# CITY OF ALBUQUERQUE

November 17, 2021

**Re: Adina Assisted Living**  
**12105 Sierra Grande Ave. NE**  
**Traffic Circulation Layout**  
Architect's Stamp 11-17-2021 (J22-D072)

TRAFFIC CIRCULATION LAYOUT

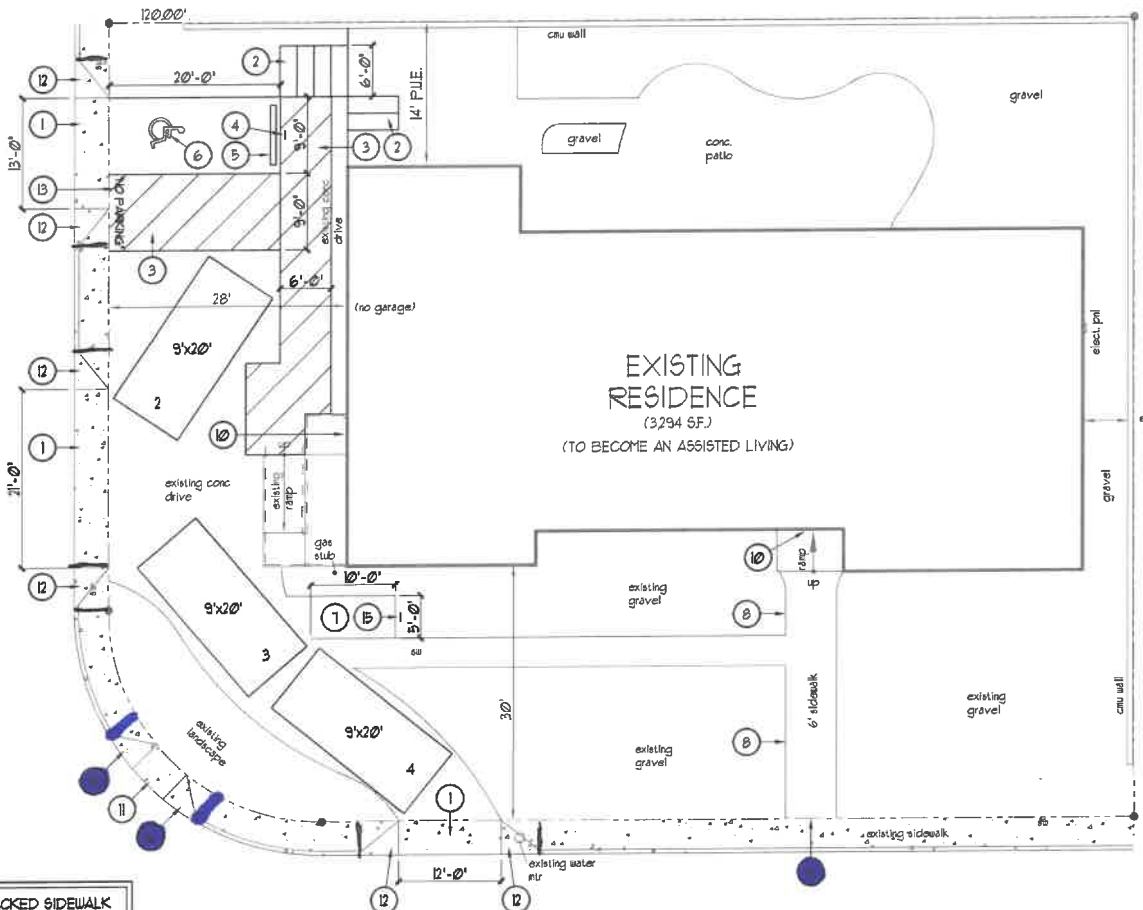
1. The ADA accessible parking sign must have the required language per 66-7-352.4C NMSA 1978 **"Violators Are Subject to a Fine and/or Towing."** Please call out detail and location of signs.

2. The ADA access aisles shall have the words **"NO PARKING"** in capital letters, each of which shall be at least one foot high and at least two inches wide, placed at the rear of the parking space so as to be close to where an adjacent vehicle's rear tire would be placed. (66-1-4.1.B NMSA 1978) .

3. Striping details (stripe thickness, spacing and color) will need to be provided.
4. ADA curb ramps must be updated to current standards and have truncated domes installed. Label proposed ADA ramp, at corner, detail per COA std dwg 2441.

5. **Motorcycle parking:**
  - Spaces shall be designated by its own conspicuously posted upright sign, either free-standing or wall mounted per the zoning code. Provide sign face detail and post detail.

- Label pavement MC.
6. All bicycle racks shall be designed according to the following guidelines:
  - a. The rack shall be a minimum 30 inches tall and 18 inches wide.

- b. The bicycle frame shall be supported horizontally at two or more places. Comb/toaster racks are not allowed.
  - c. The rack shall be designed to support the bicycle in an upright position. See the IDO for additional information.

- d. The rack allows varying bicycle frame sizes and styles to be attached.
  - e. The user is not required to lift the bicycle onto the bicycle rack.

- f. Each bicycle parking space is accessible without moving another bicycle.

7. Bicycle racks shall be sturdy and anchored to a concrete pad.
8. A 1-foot clear zone around the bicycle parking stall shall be provided.
9. Bicycle parking spaces shall be at least 6 feet long and 2 feet wide.
10. Modify drivepad to **COA std dwg\_2425A** and Add this reference note.
11. Add a note stating "All broken or cracked sidewalk must be replaced with sidewalk and curb & gutter." A build note must be provided referring to the appropriate **City Standard drawing (2430 & 2415A)**.
12. Please provide a letter of response for all comments given.
